From: Amanda Scholes on behalf of Planning.Responses
Sent: 20 November 2018 10:52
To: Planning Scanning
Subject: FW: Land at Lidsey AL/20/18/OUT

CHA have raised a new issue about the risk that HGVs 'might over-sail the centreline when travelling south'. The drawing OCL/SR/701 Rev D shows that the route of the A29 is widened to at least 3.75m per lane, widening to 4.25m per lane at the access. Circa 10m to the south of the new access the lane widths are 4.15m each. The correct plans and the swept paths showing that two HGVs could pass each other with ease were attached to the original Transport Statement. For reference, I have attached the swept path to this email. As you can see there is plenty of room between the two HGVs as they pass each other. The camber of the A29 will also mean that HGVs will be leaning away from each other. There is no risk that HGVs would over-sail. Equally so this matter can be addressed at the detailed design stage.

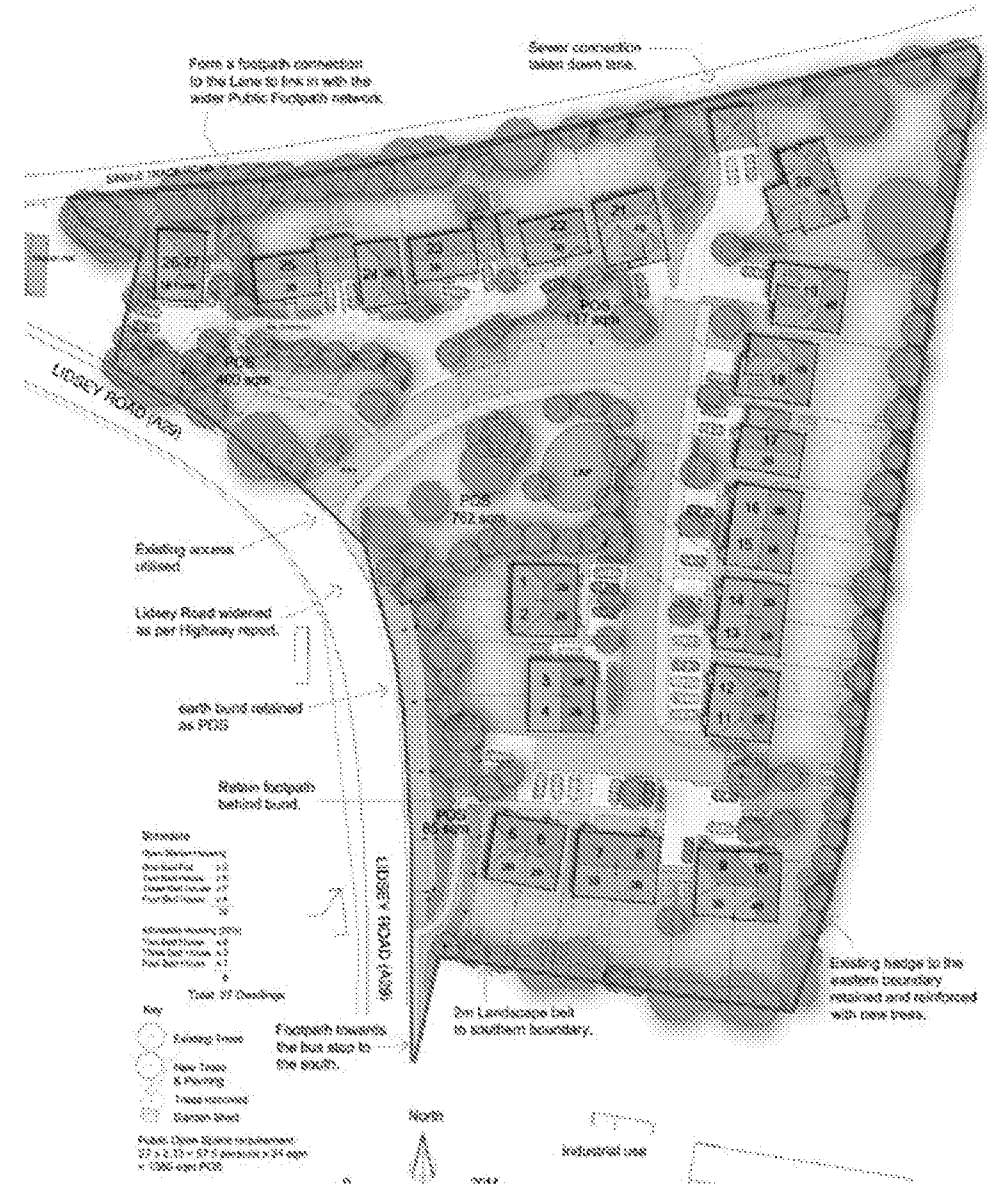
CHA are referring to DWG 1749-02H in the comments about the bellmouth. This is the 'Illustrative Site Plan' of the proposal. We have shown on OCL/SR/701 Rev D the appropriate detail of the bellmouth and the reasoning for the tightness of the radii has been discussed in great detail. CHA had agreed that the detailing of the bellmouth can be agreed at the detailed design stage, once the scheme has been subjected to the Stage 2 Road Safety Audit.

It would seem that the CHA are now basing their concerns on the 'Illustrative Site Plan' DWG 1749-02H. It is not unusual for there to be some discrepancies between illustrative plans submitted as part of the application and (in this case) the 4th iteration of the highway layout plan. We have provided more than enough information to show
